REQUEST

Current Zoning: N1-A (neighborhood 1-A) and CG (general Commercial)
 Proposed Zoning: N2-B(CD) (neighborhood 2-B, conditional)

Approximately 16.15 acres located at the northeast intersection of Beatties Ford Road and Trinity Road, south of Lakeview Road.

The petition proposes the development of up to 147 duplex, triplex, quadraplex, and multi-family attached dwelling units, including up to 5 live work units. The site is currently wooded and vacant.

TRINITY PARK TOWNHOMES

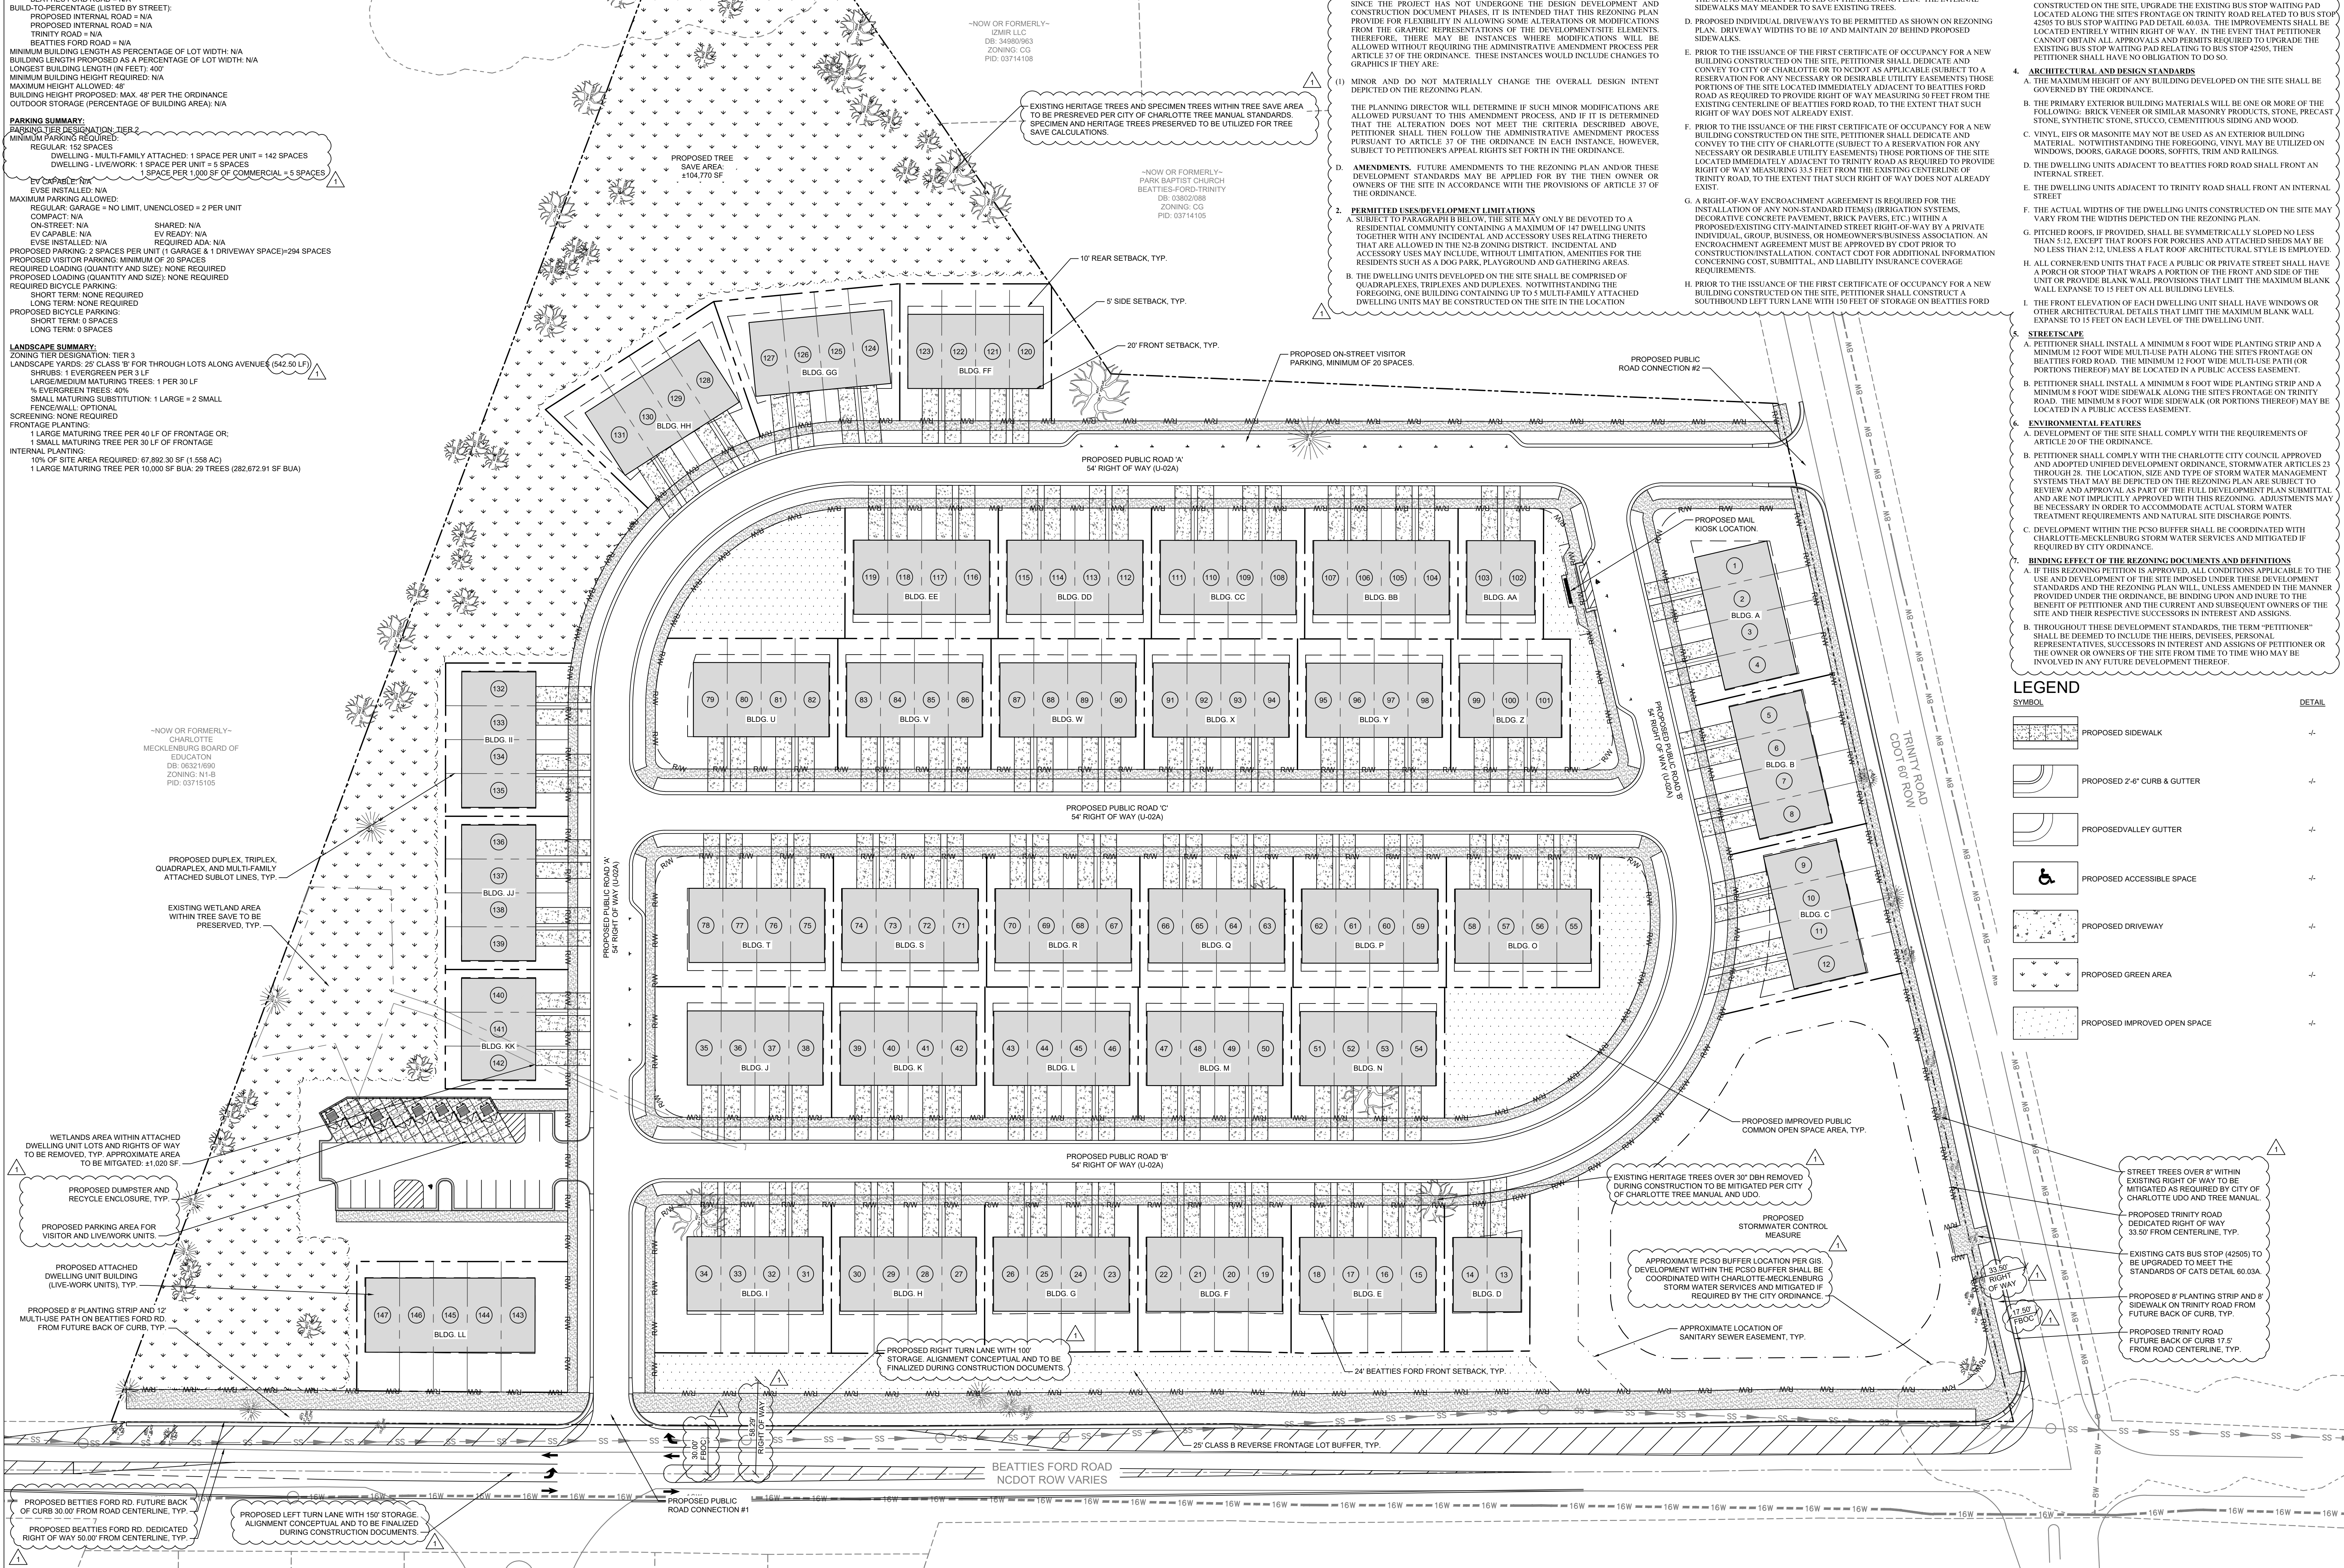
2. Please show sidewalk connecting at the corner of Beatties Ford Rd. and Trinity Rd. Site plan does not clearly show they are connected to either existing or proposed streetscape.
-
